**Tillbridge Solar Project
EN010142**

**Volume 6.2
Environmental Statement
Appendix 10-5: Water Environment Stakeholder
Correspondence
Document Reference: EN010142/APP/6.2**

Our ref: AN/2023/134332/01-L01

**Tillbridge Solar Scheme, south of the A631 between Heaptham and Hartswell –
Flood Risk Assessment review**

PLAN OF TYPICAL THRUST BORE ARRANGEMENT UNDER SENSITIVE WATERCOURSE
SCALE: 1:200

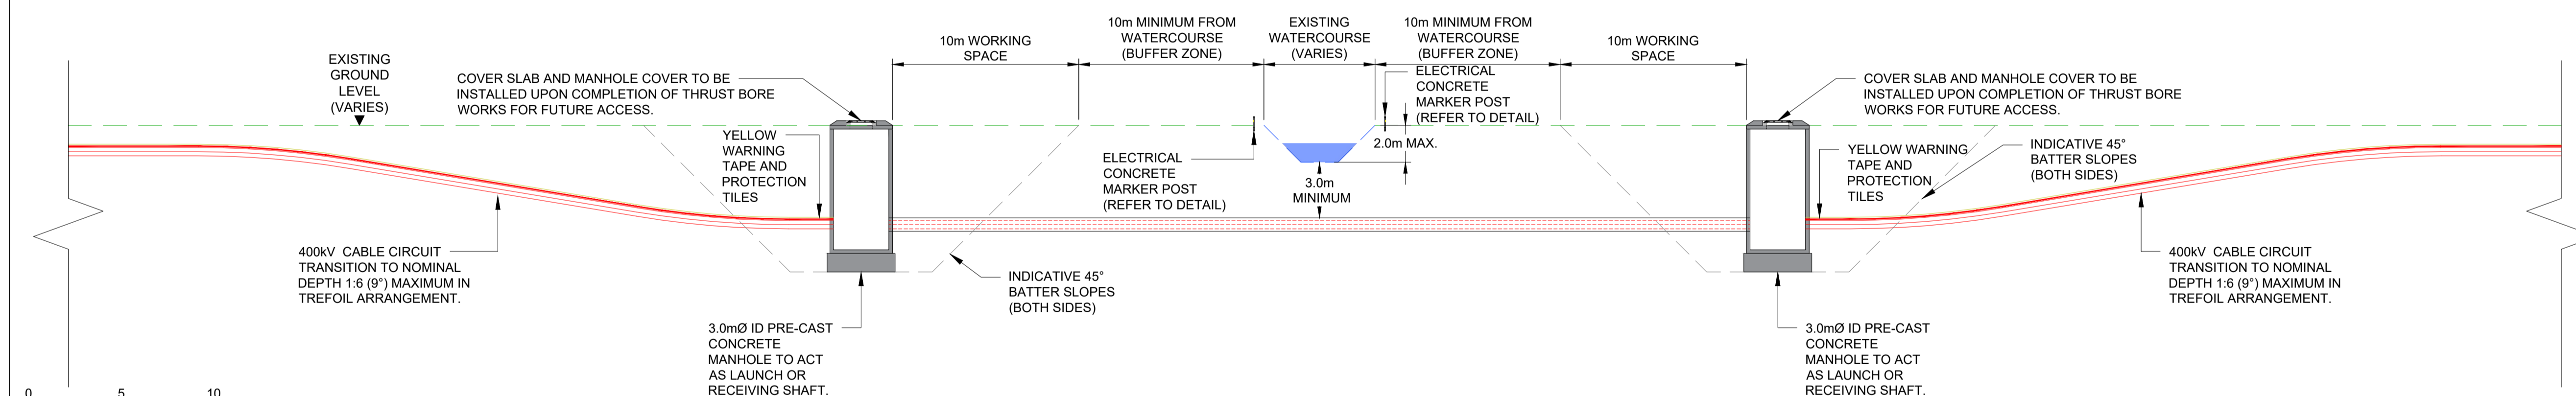
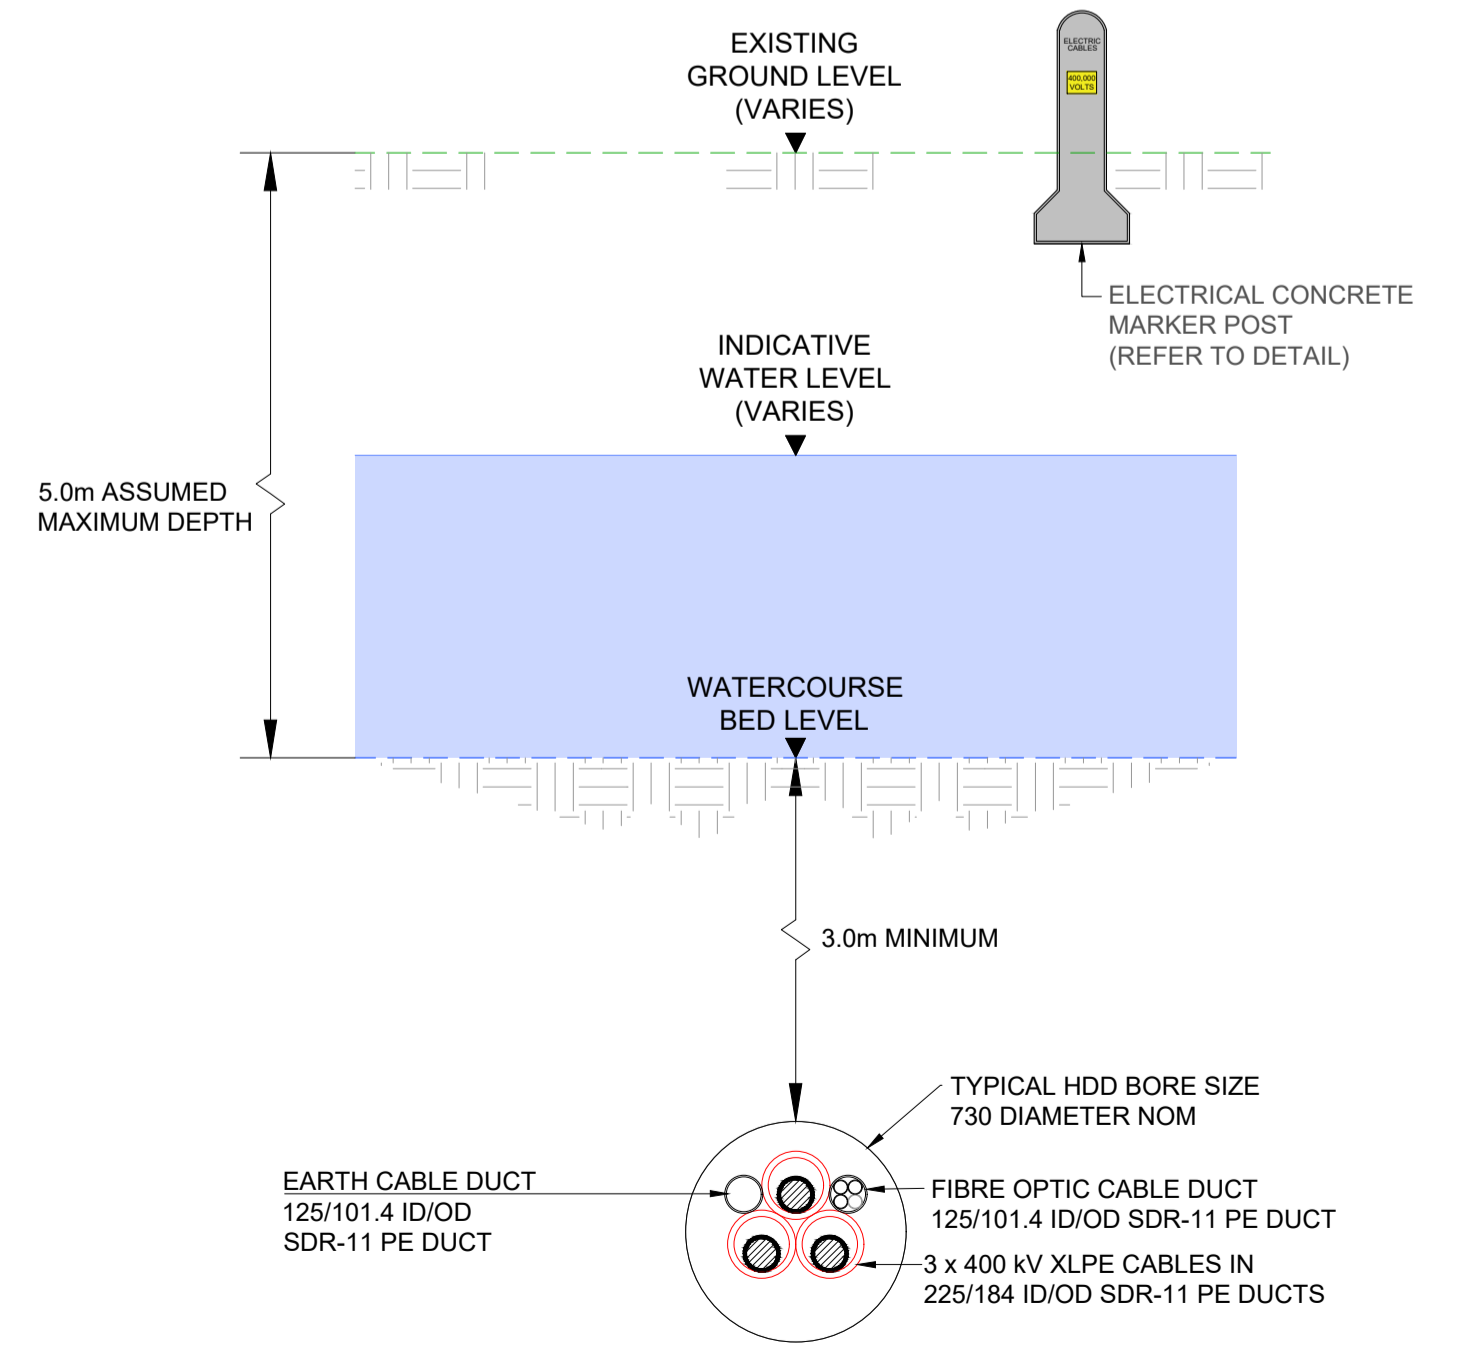
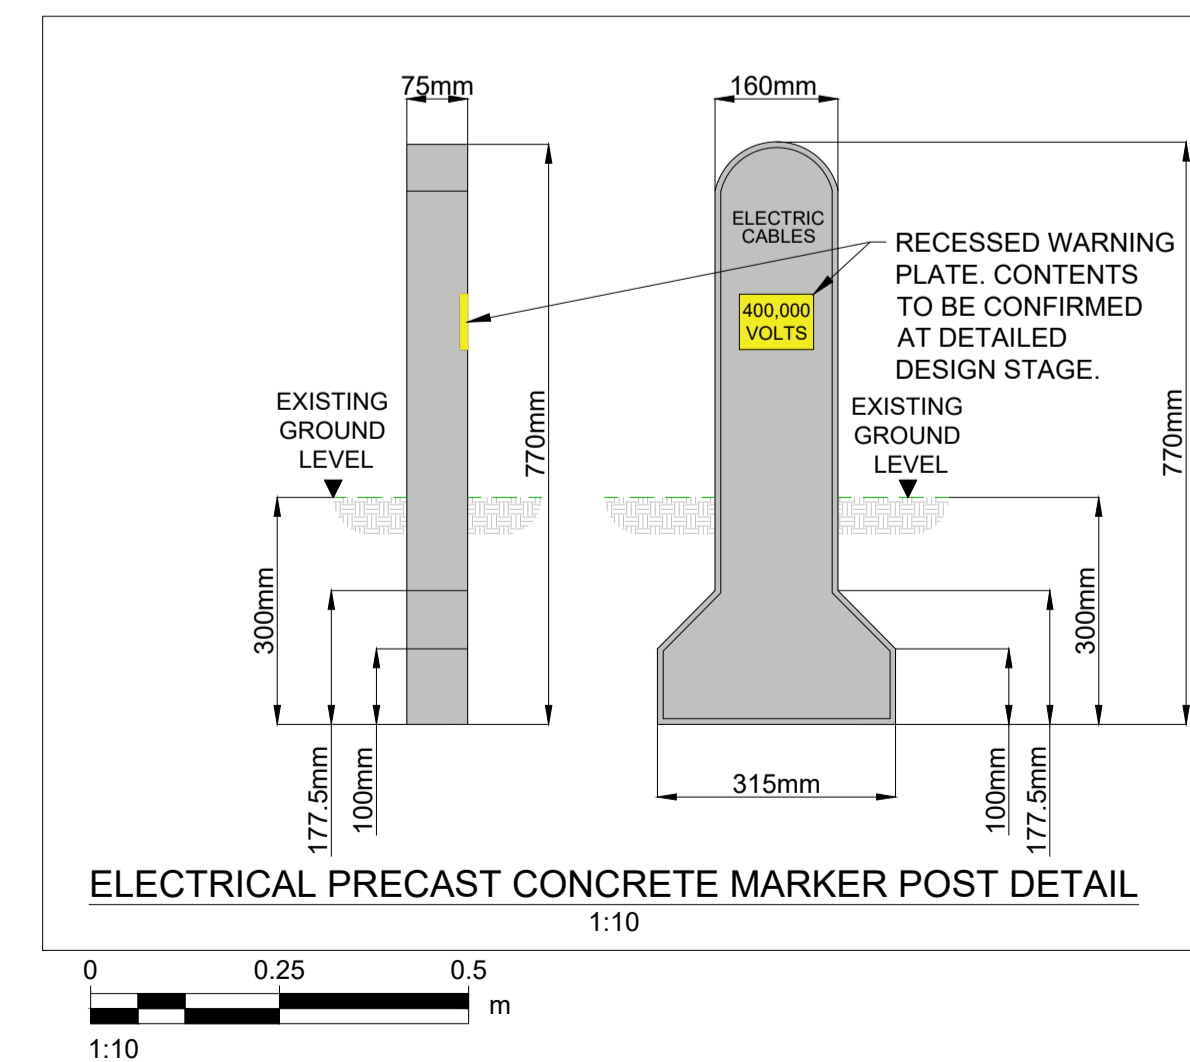
We note that the FRA has focused on flood risk to the Principal Site, as the Cable Route Corridor will all be underground with no permanent above-ground (built) development. However, the cable route includes two Main River crossings; the River Till and the River Trent. The construction/installation phase of the Cable Route Corridor has the potential to have a detrimental impact on flood risk, particularly where it crosses under the Main River channels. You will need to ensure that the methodology employed for the crossings has no impact on the river channel or flood risk.

We would advise you to carry out the river crossings in line with the criteria set out within the exemption parameters known as "Flood Risk Activity 3. Service Crossing below the bed of a main river not involving an open cut technique (FRA3)" – [Exempt flood risk activities: environmental permits - GOV.UK \(www.gov.uk\)](http://www.gov.uk).
